DEVIATION REQUEST AND DECISION FORM

May 2022 Deviation Request Typical Section

Project Name : Forest Heights Estates

TYPICAL PRIVATE RURAL ROADWAY SECTION RURAL GRAVEL LOCAL ROADWAY WITH A DESIGN AND POSTED SPEED OF 20 MPH

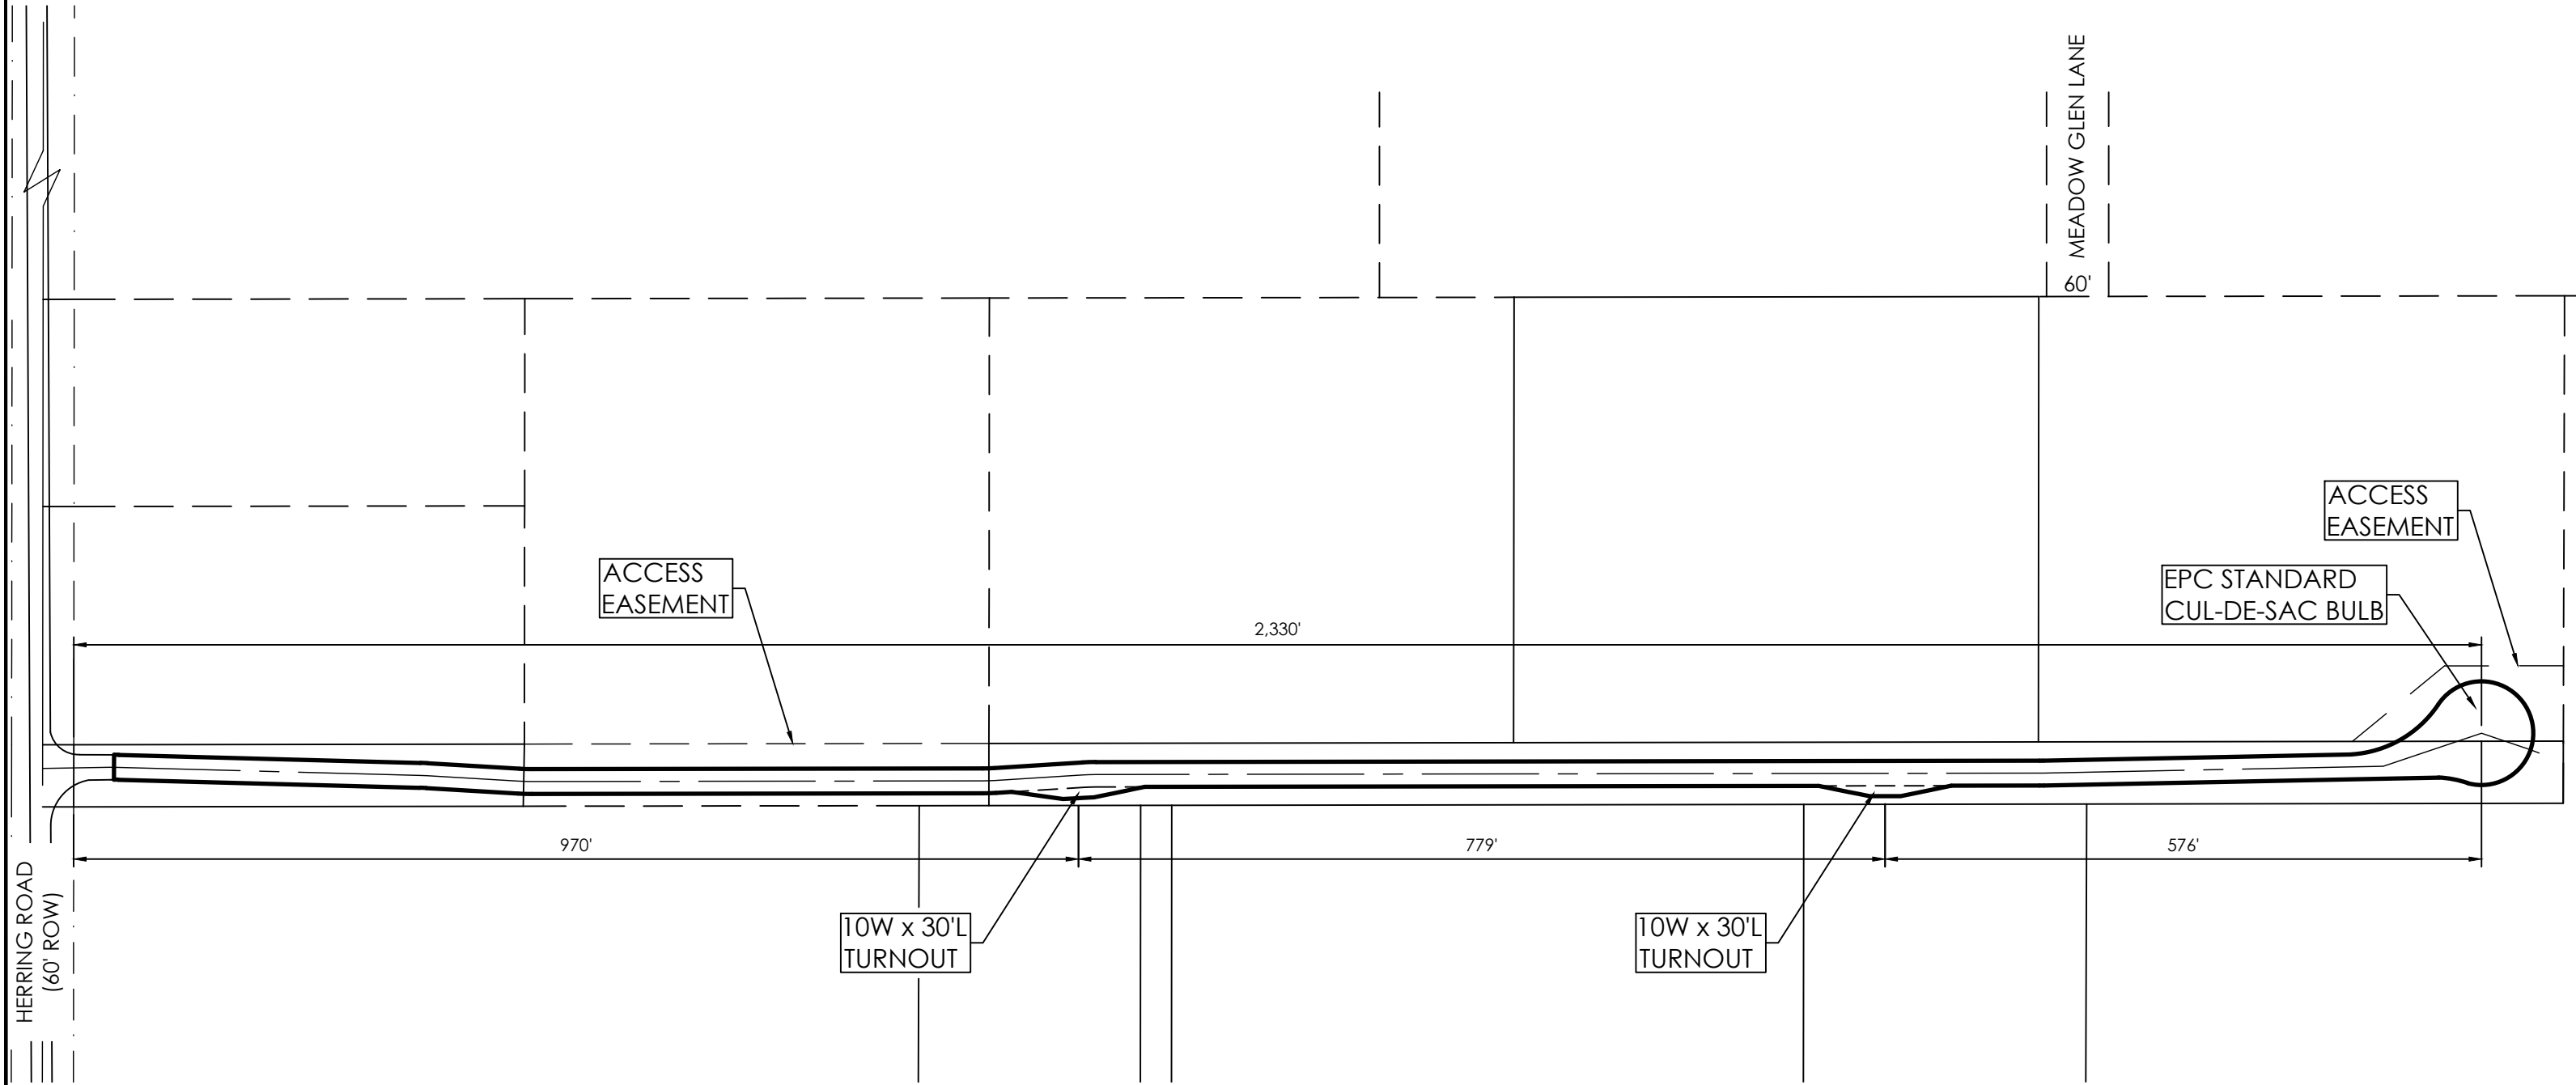
Please revise/remove as the detail on the construction drawings show a 6:1 slope

See comment above
and remove
